COMMENT RESPONSE LETTER

To: Albuquerque Water Utility Authority
From: RESPEC
Date: June 14, 2024
RE: Application For: SI-2024-00547 – EPC site plan sign-off

UTILITY PLAN COMMENT RESPONSES

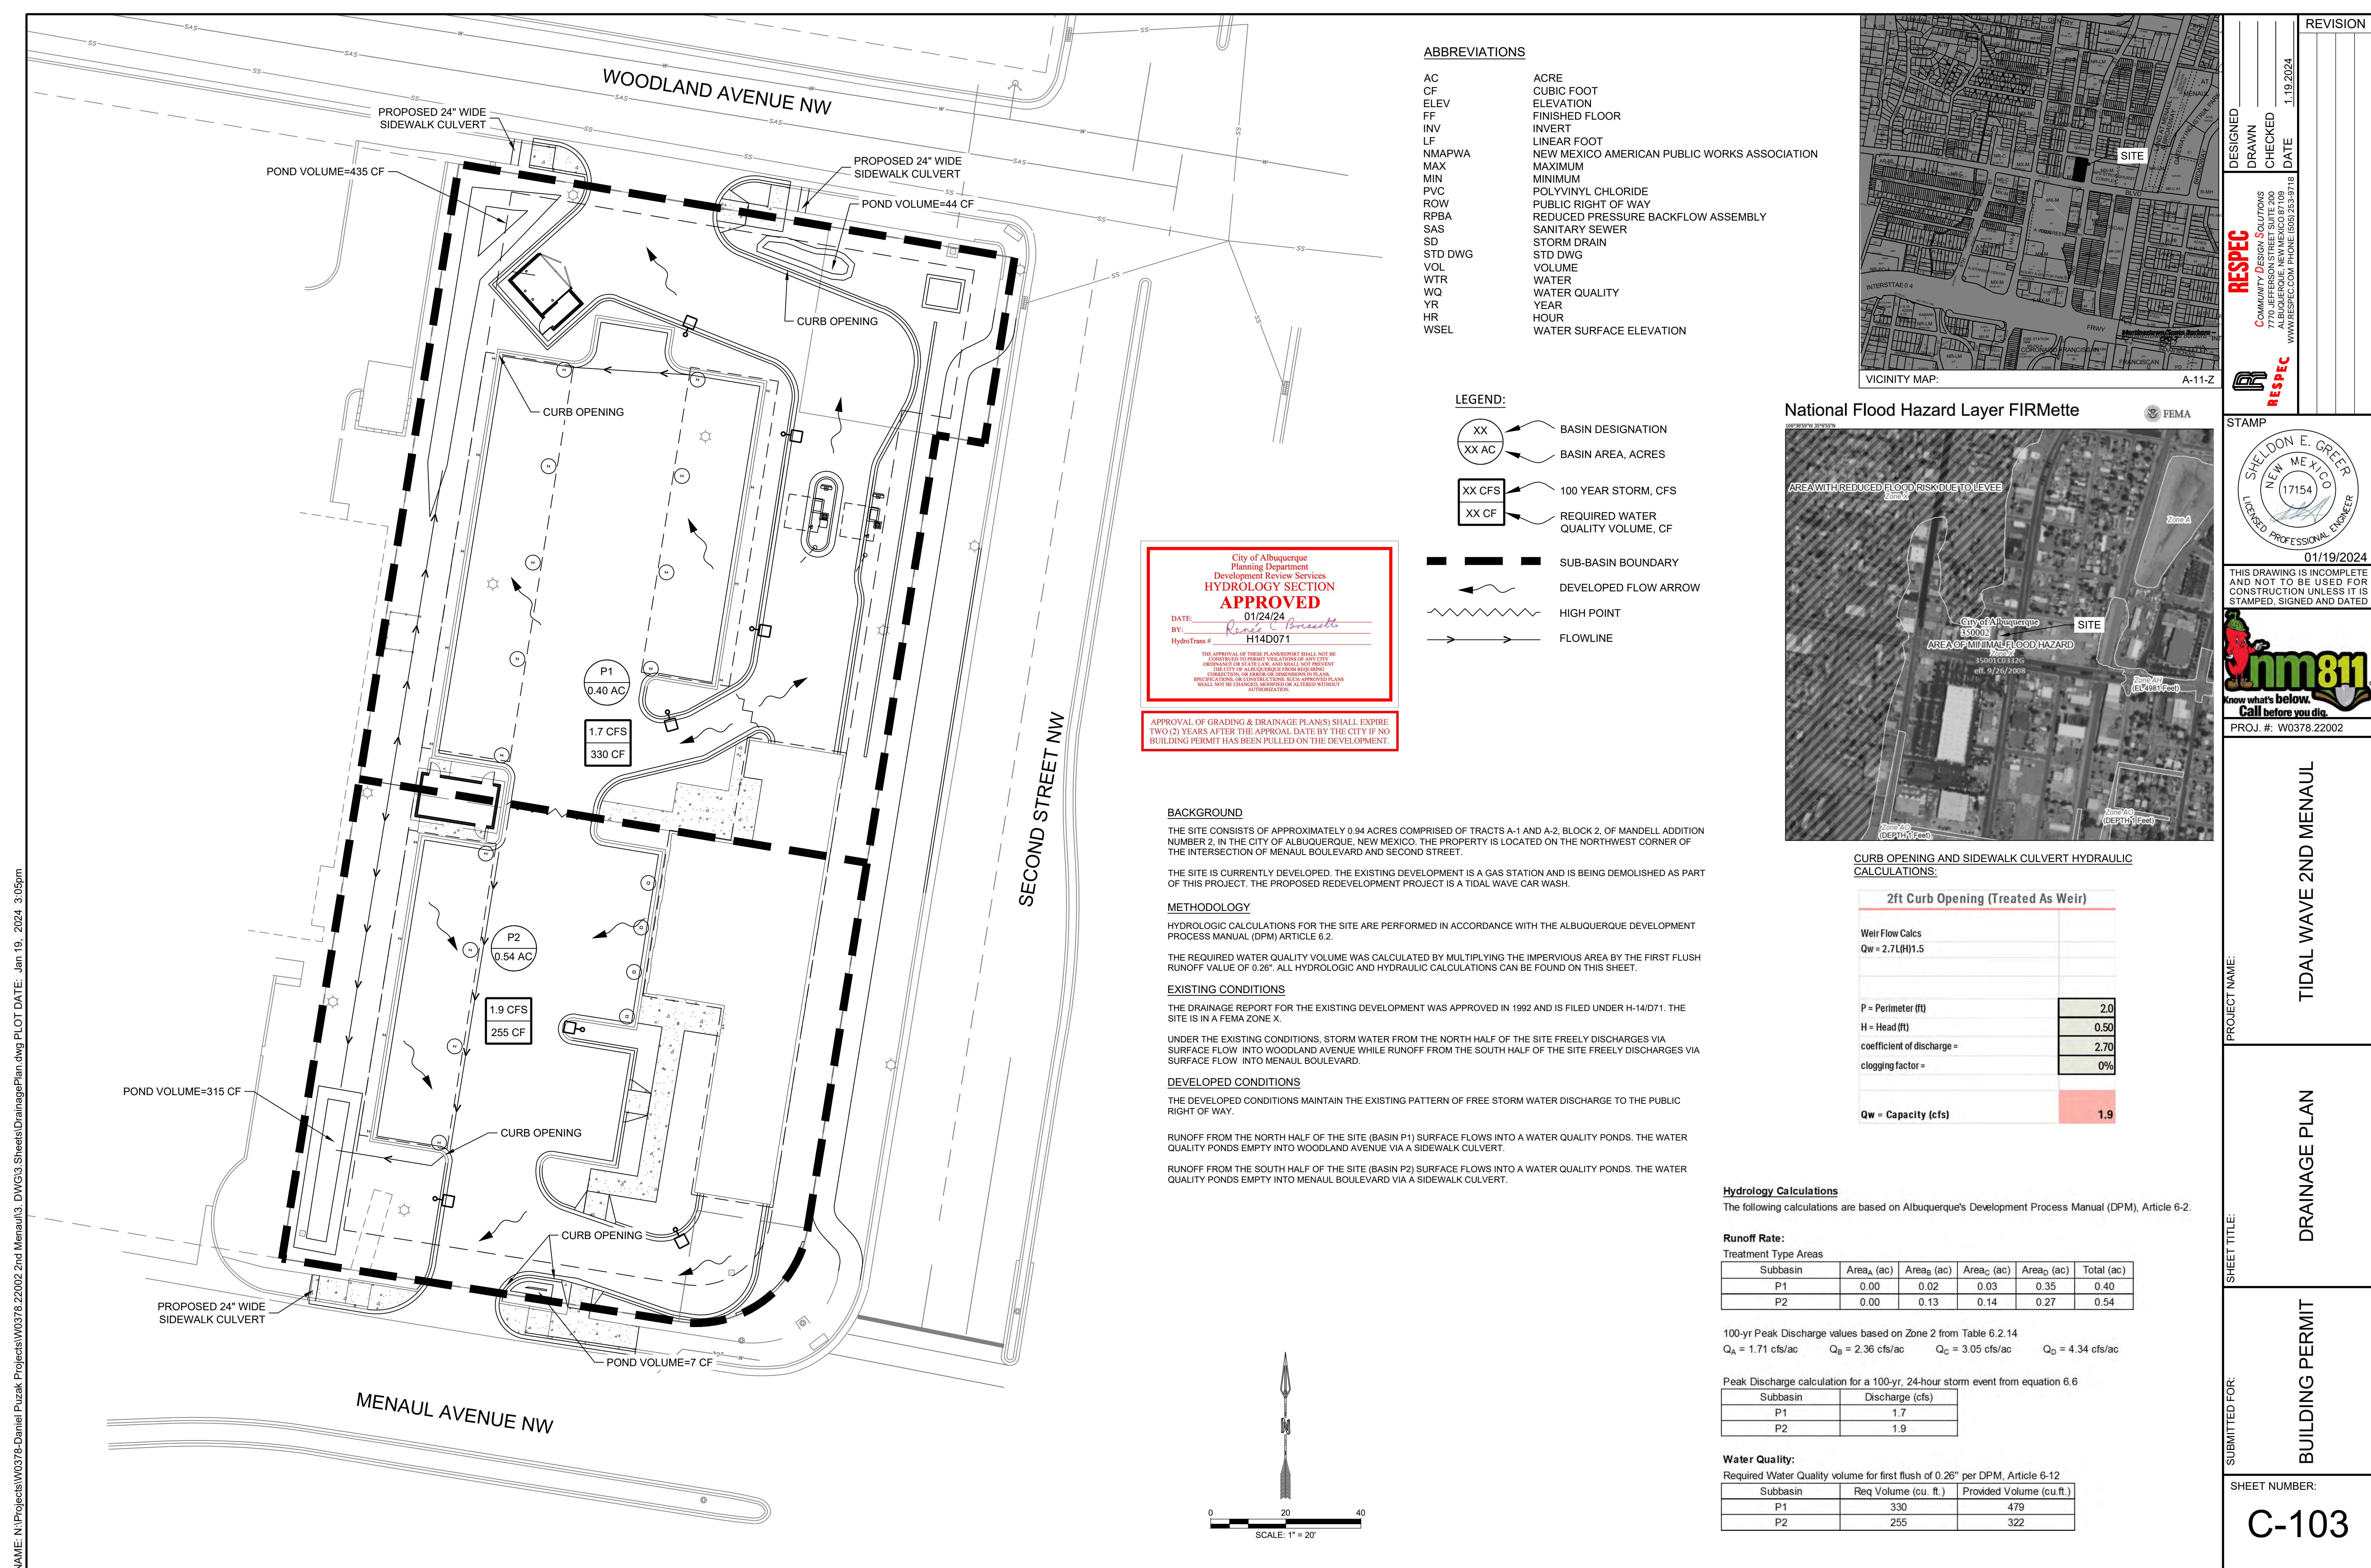
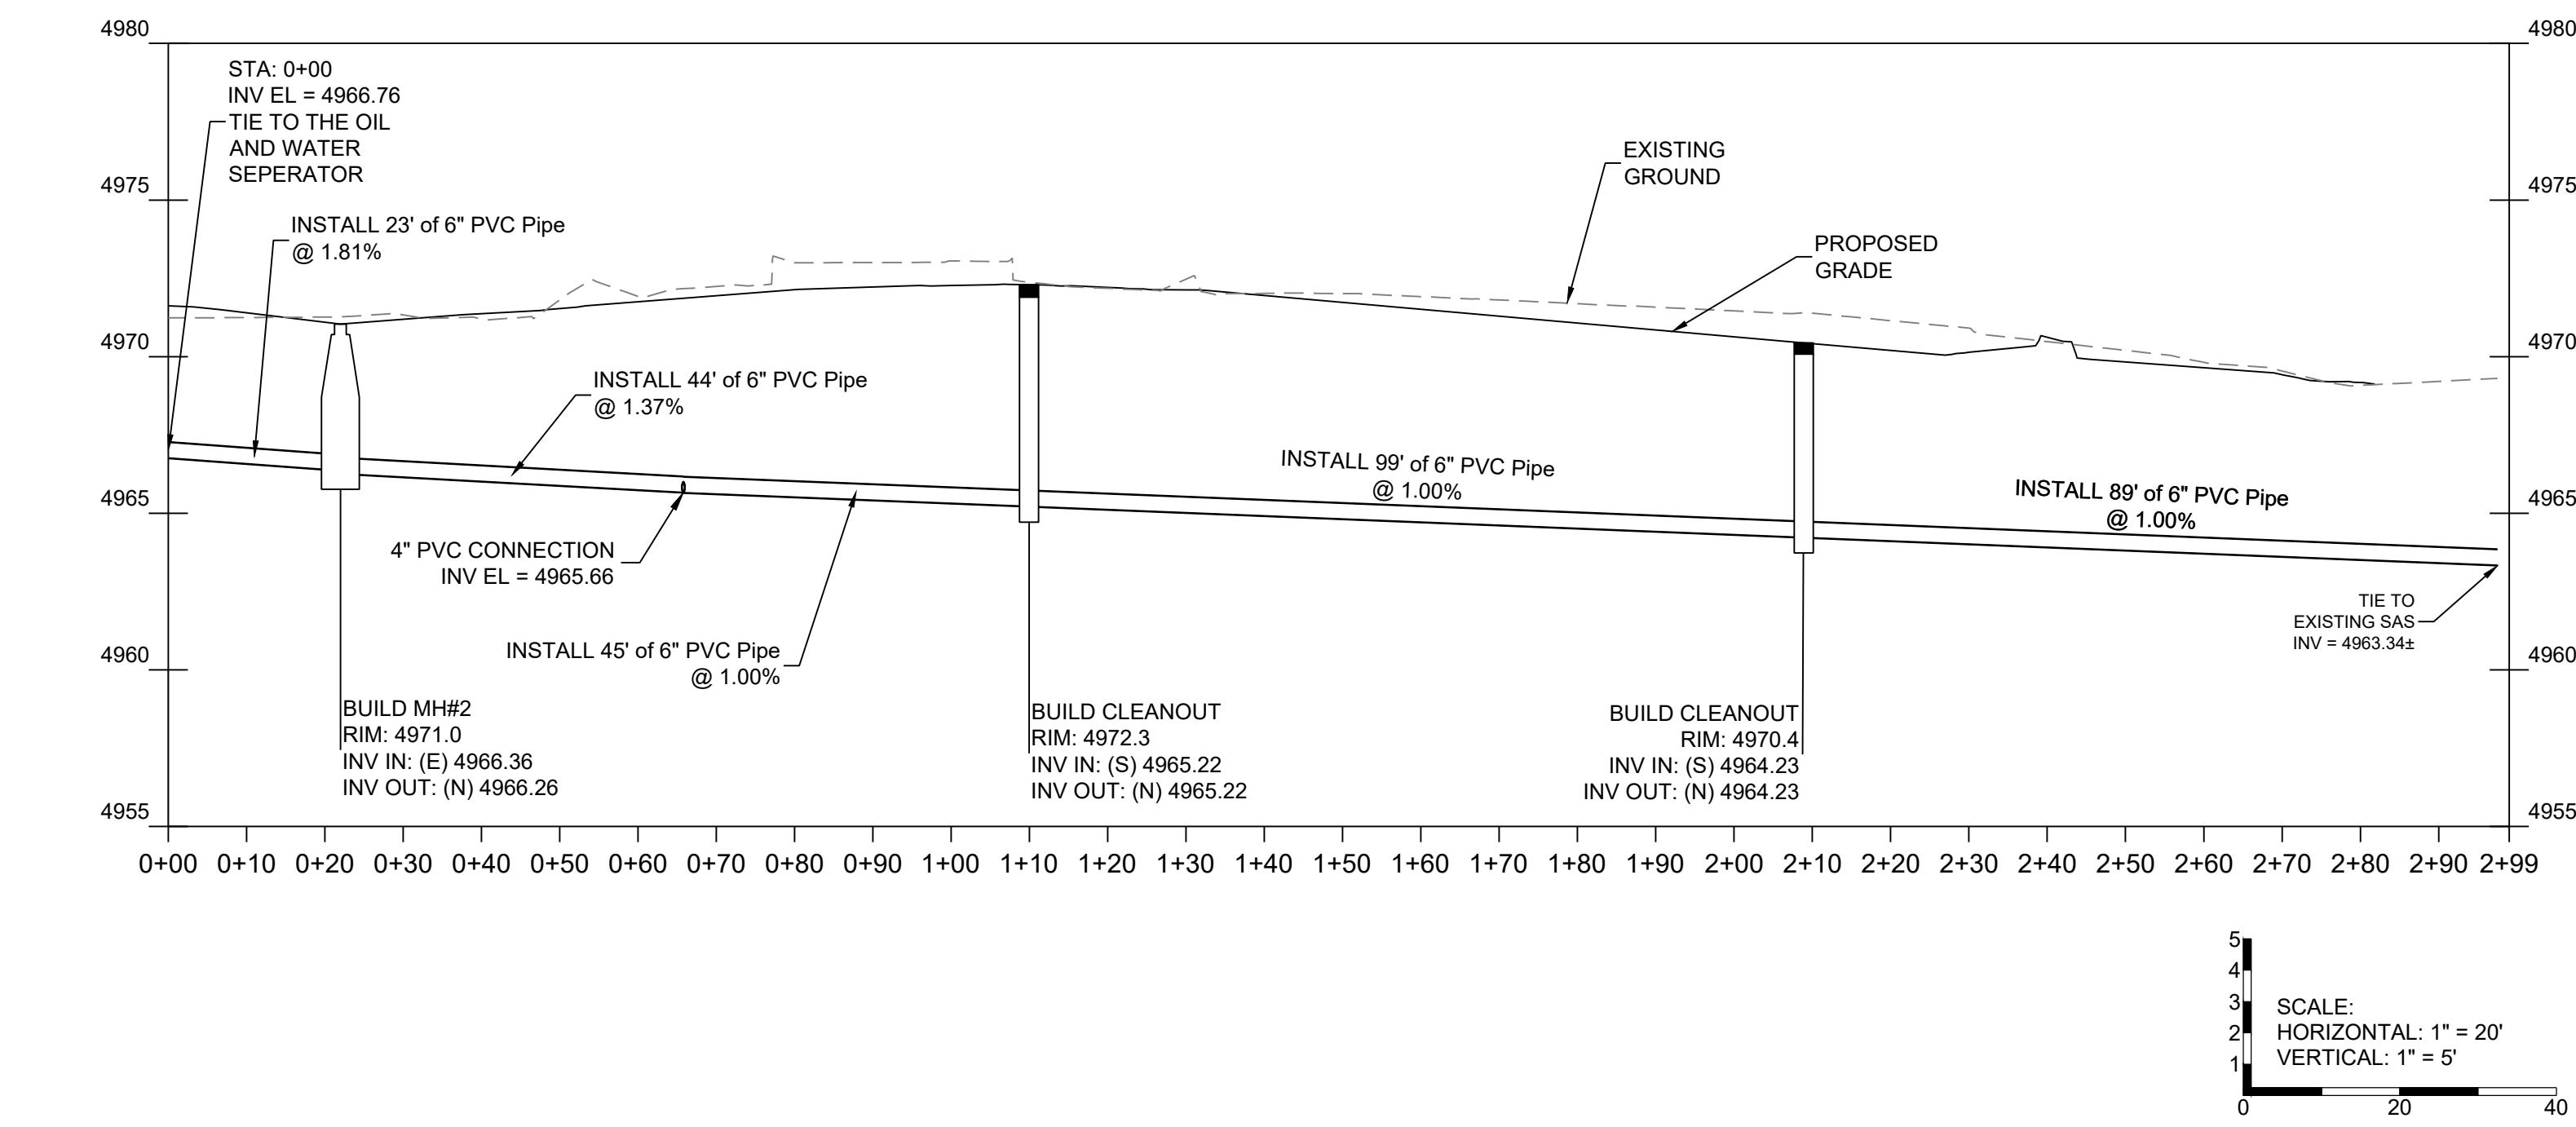
- a. Please add the following notes to the Master Utility Plan. Additionally, please coordinate ahead of time with the
- i. Coordination with Water Authority Cross Connection Section will be required to ensure proper backflow containment is in place prior to release of meter for the site. Contact the Cross Connection Section at 505-289-3454.
 - ii. Coordination with the Water Authority Pre-Treatment Engineer is required to ensure the site complies with Water Authority Sewer Use Ordinance. Contact the Pre-Treatment Engineer at 505-289-3439.

- b. Please appropriately label infrastructure as public or private.
[A note has been added to the utility plan that addresses this.](#)

c. Please figure out if the existing meter is adequate size or not to avoid ambiguity. If needed, please contact our customer service to get someone to meet you out there to determine the size.

- i. Currently the bill size is a size 2 which indicates it is sized for a 1" meter.
- ii. There is also an account showing a size 1 which is a ¾ inch meter.
- iii. Please research and determine what will happen with these existing services. Any that are unused will need to be abandoned (shutoff and removed to the corporation stop).

[These notes have been added to the utility plan.](#)

[The existing 1 inch meter located to the north of the site will be removed and replaced with a 1½ inch meter. The existing ¾ inch meter located to the northeast of the site will be reused as an irrigation meter.](#)
